**Re: Yearwood Bldg Grading and Drainage Plan  
Engineer's Stamp dated 8-13-10(K20-D58)**

**RE: Grading and Drainage Plan  
Yearwood(K20-D058)**

**Re: Yearwood, 341 Eubank NE**  
**Grading and Drainage Plan**  
**Engineer's Stamp dated 05-26-10 (K20-D058)**

ENGINEER'S SEAL	YEARWOOD 341 EUBANK GRADING AND DRAINAGE PLAN	DRAWN BY WCHJ
DAVID SOULE P.E. #14522	Rio Grande Engineering 1606 CENTRAL AVENUE SUITE 201 ALBUQUERQUE, NM 87106 (505) 972-0899	DATE 8-13-10 2115-LAYOUT-5-18-10
		SHEET # —
		JOB # 2115

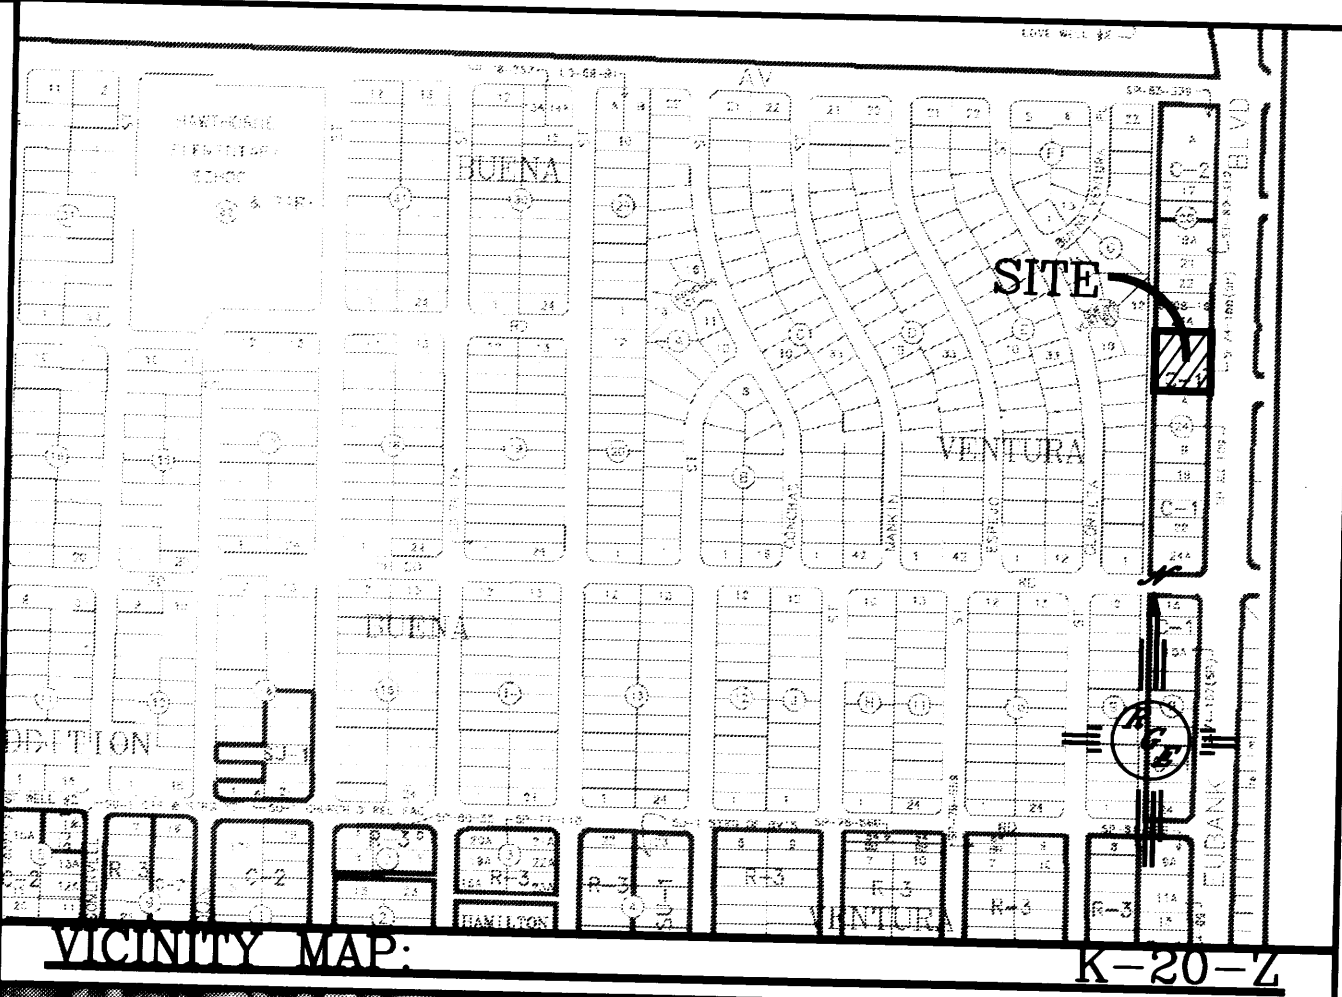
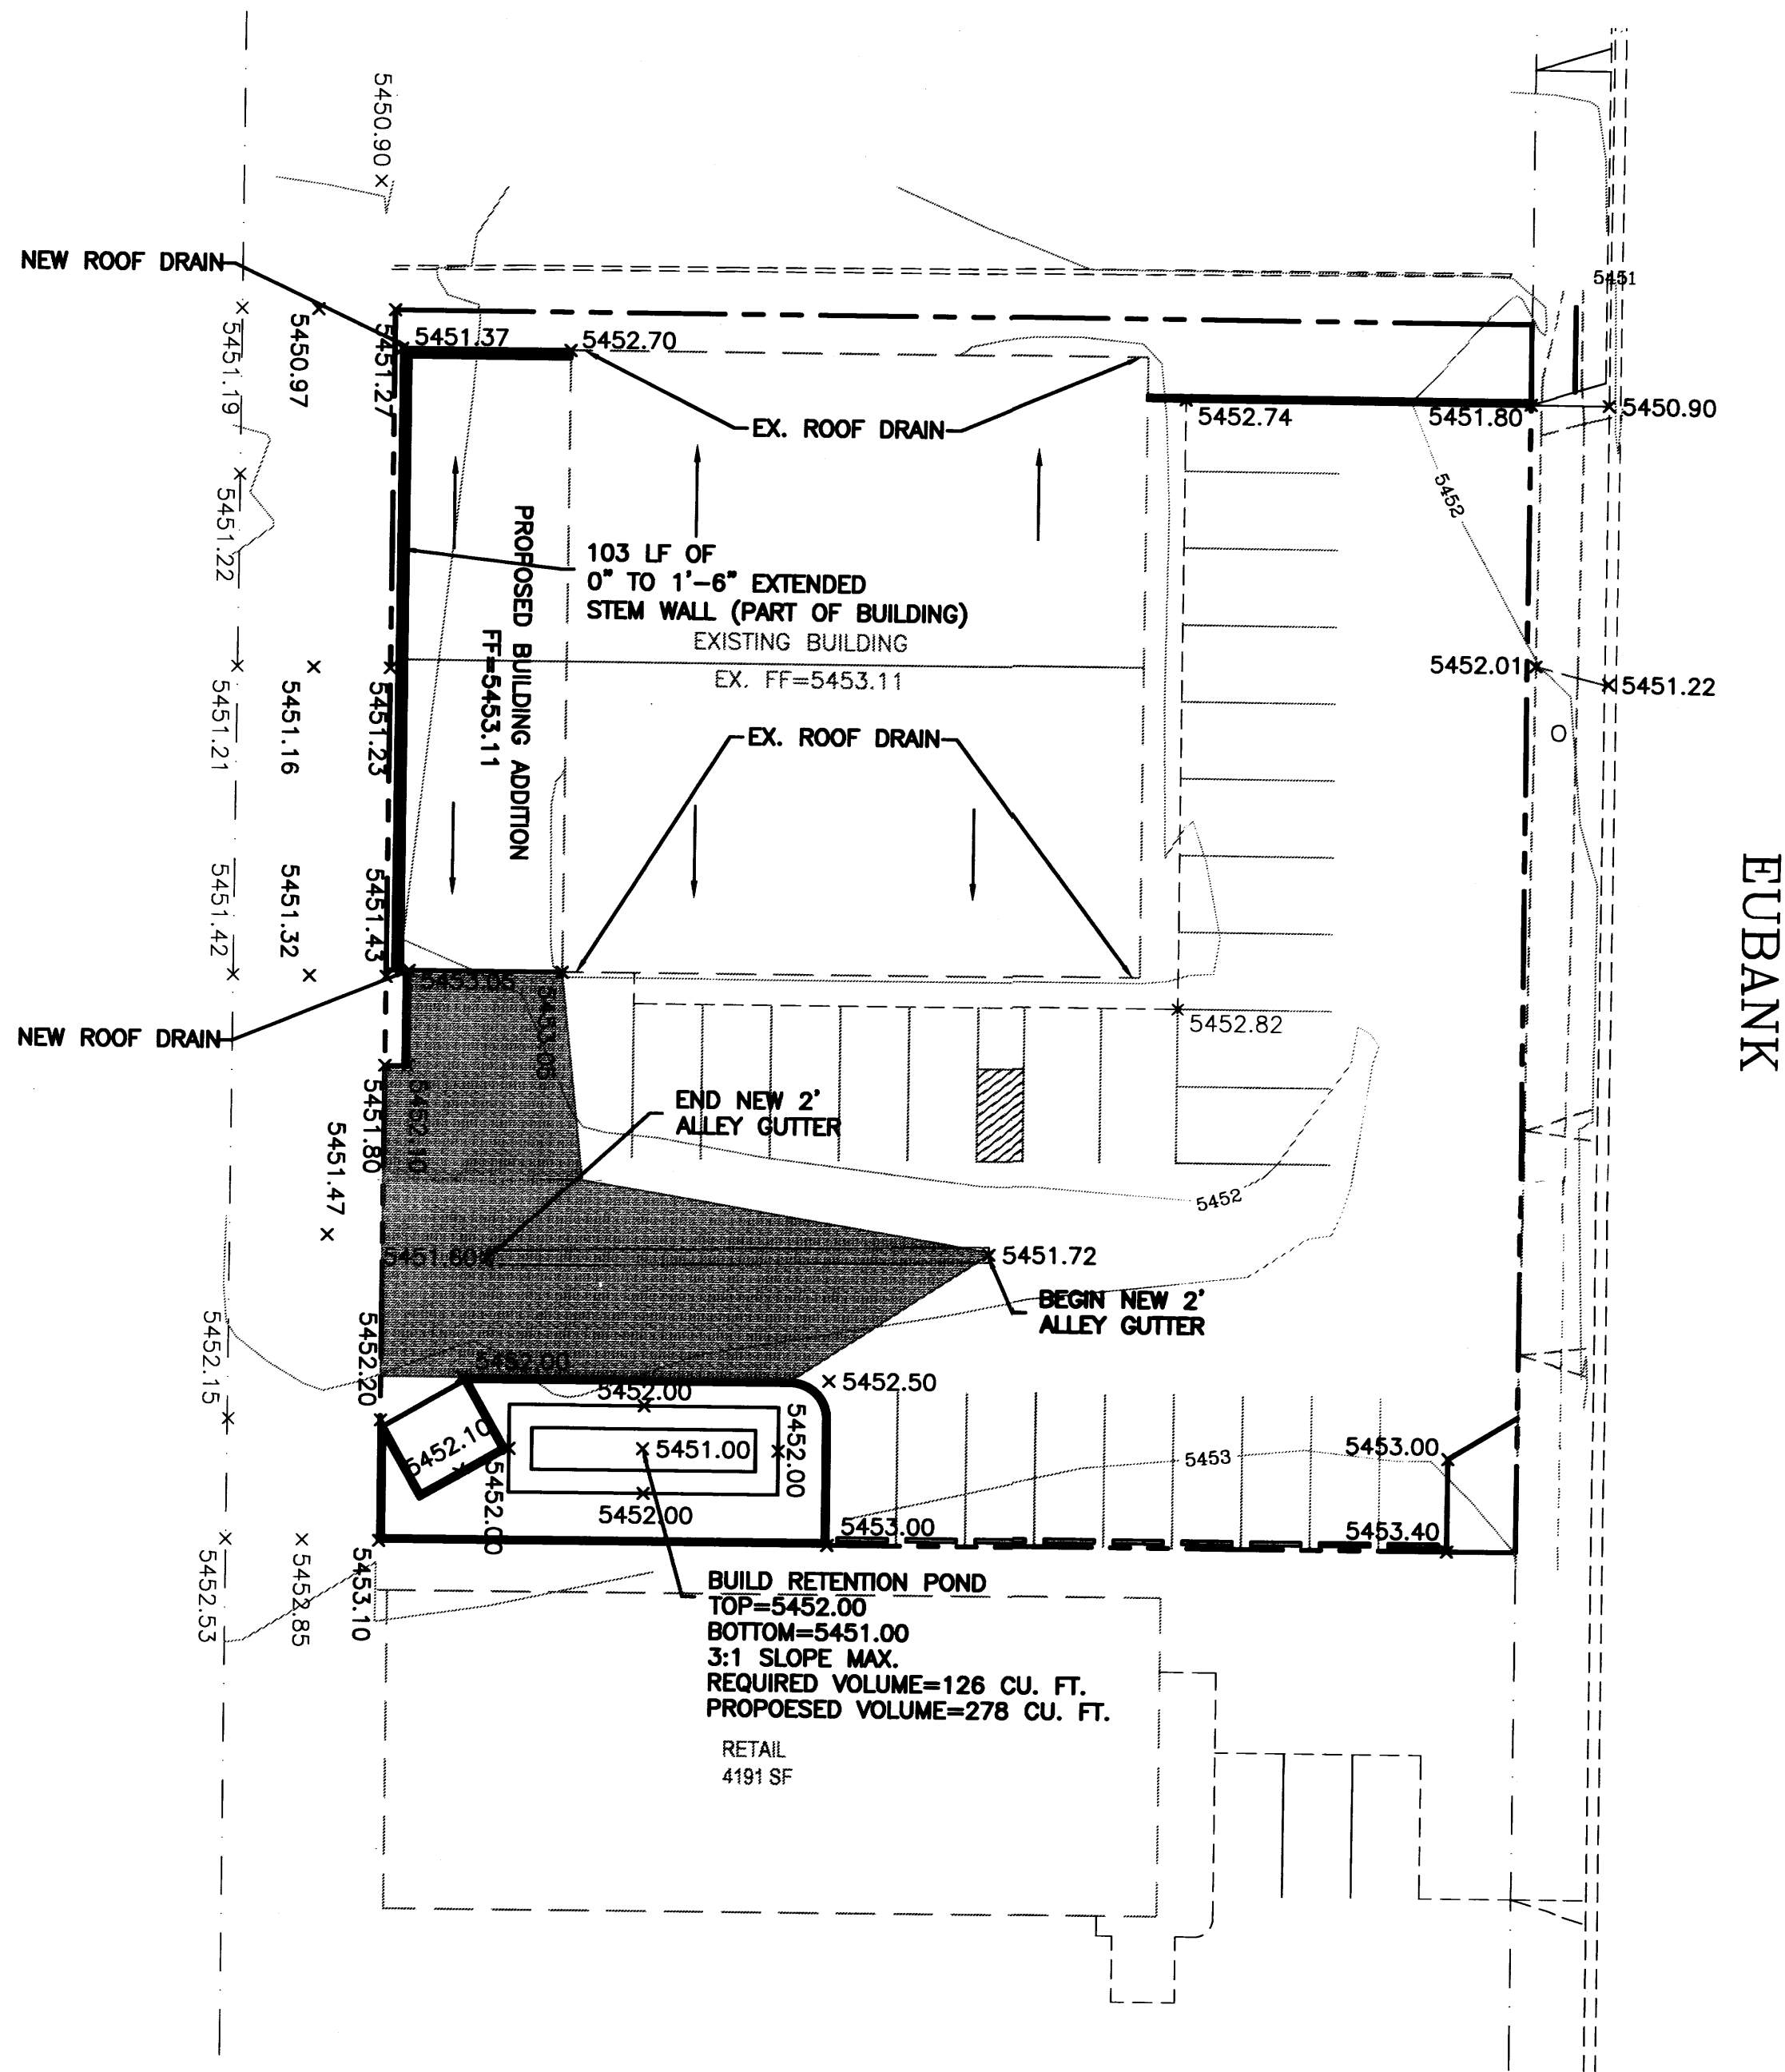
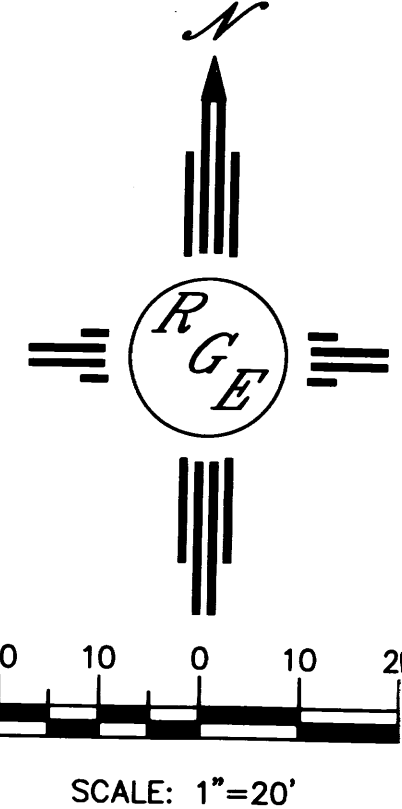
1. The new roof needs to drain into the parking lot then to the alley.

2. Is there a new landscape area at the northeast corner?

**The pitch on the roof is the same as existing. The existing gutter system will have downspouts at the corners of the building; therefore they will discharge to the site then flow into the alley.**

**No, it is an existing one, no work will be performed in this area.**
